Subject: FW: FG/51/20/HH - 66 Elm Park, Ferring

Subject: FG/51/20/HH - 66 Elm Park, Ferring

With regard to the Rev D drawings the following errors are present.

PROJECT Groome, No.66	DRAWING NO. 1459-P301	SCALE 1:100 @ A3	18	B
ADDRESS No.66 The Cottage Elm Park Ferring BN12 5RW	DRAWING TITLE Proposed North & East Elevations	DRAWN BY CRE8TIVE LINES - ROZ NOWAK	June 2020

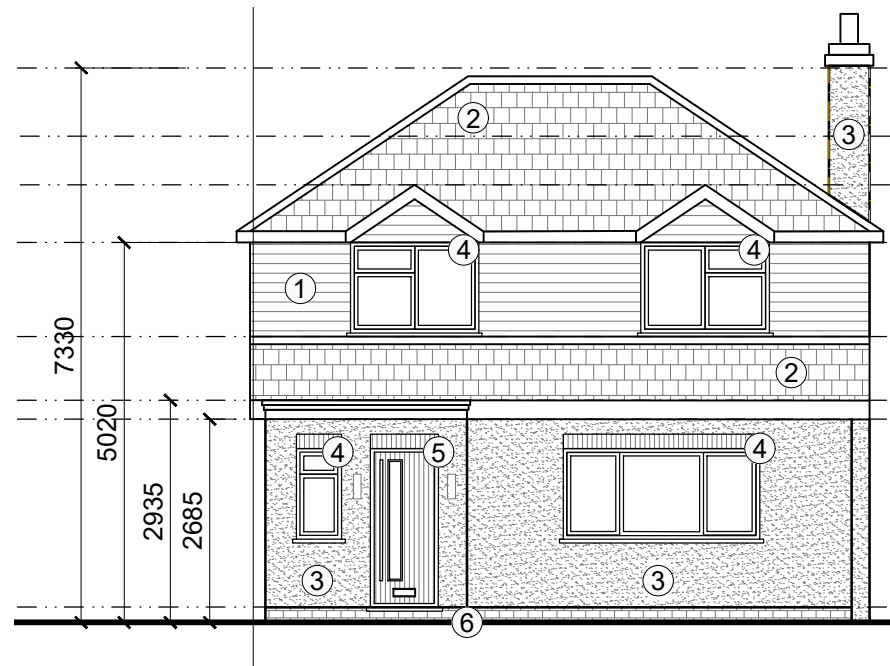
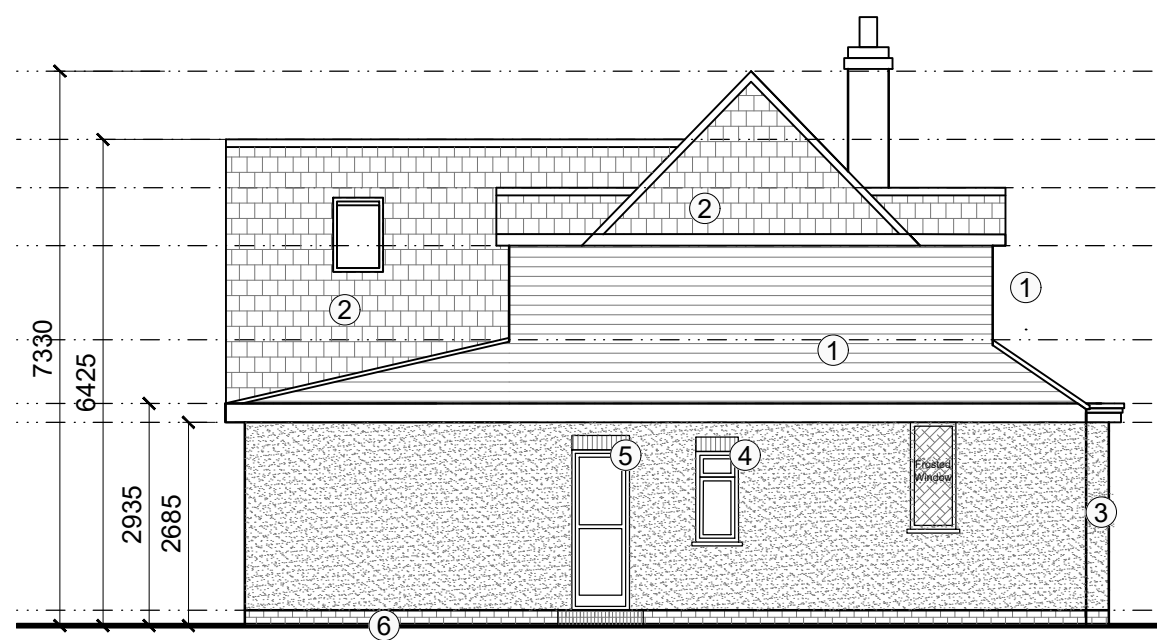
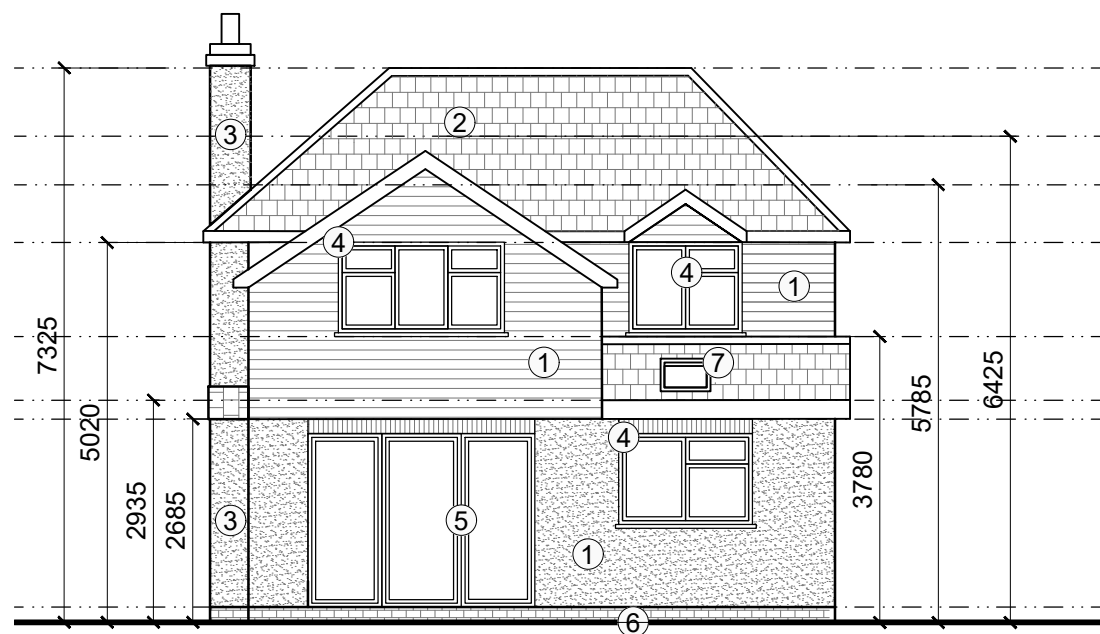
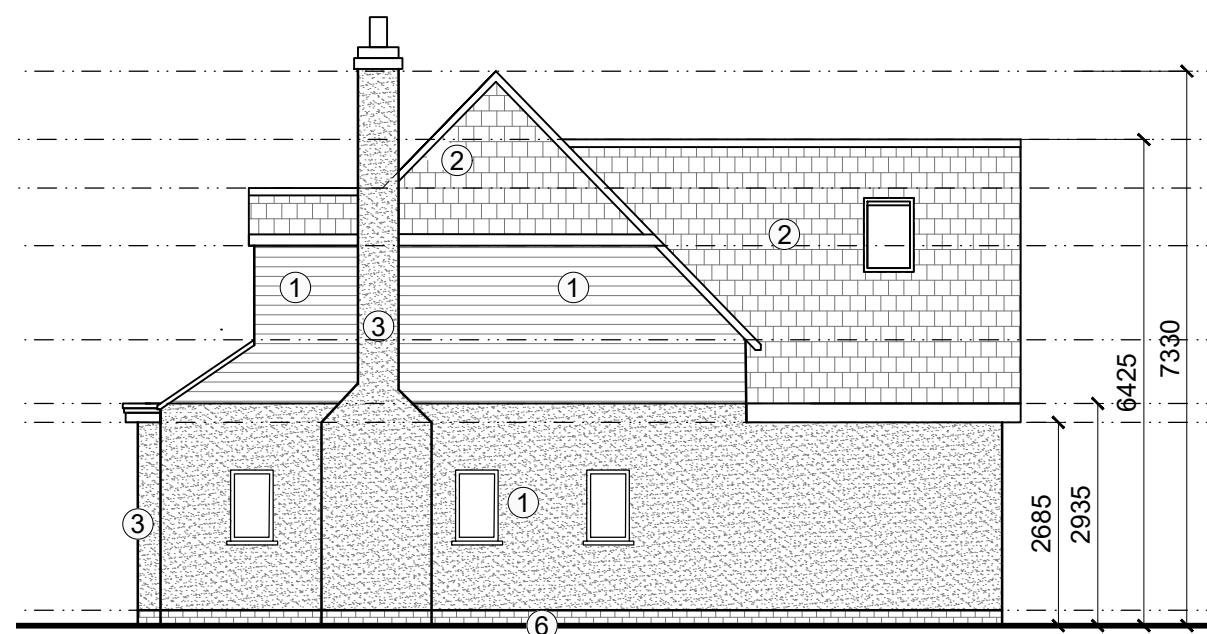
My previous comments regarding the full width dormers to the North and South elevations still stand.

1) The eaves length at the bottom of the hips on plan is different to the length on East and West elevations.

2) The width of the dormer flat roof is different on the plan/elevations. That may well be because of point 1.

Might I suggest that the negative aesthetic impact of the full width dormers could be tempered by setting the cheeks back approx.500mm from the gable face.This doesn't impact significantly on the upstairs rooms. As it stands the finish on the cheeks (tiled) is different from that on the gables (composite cladding) although they are flush?
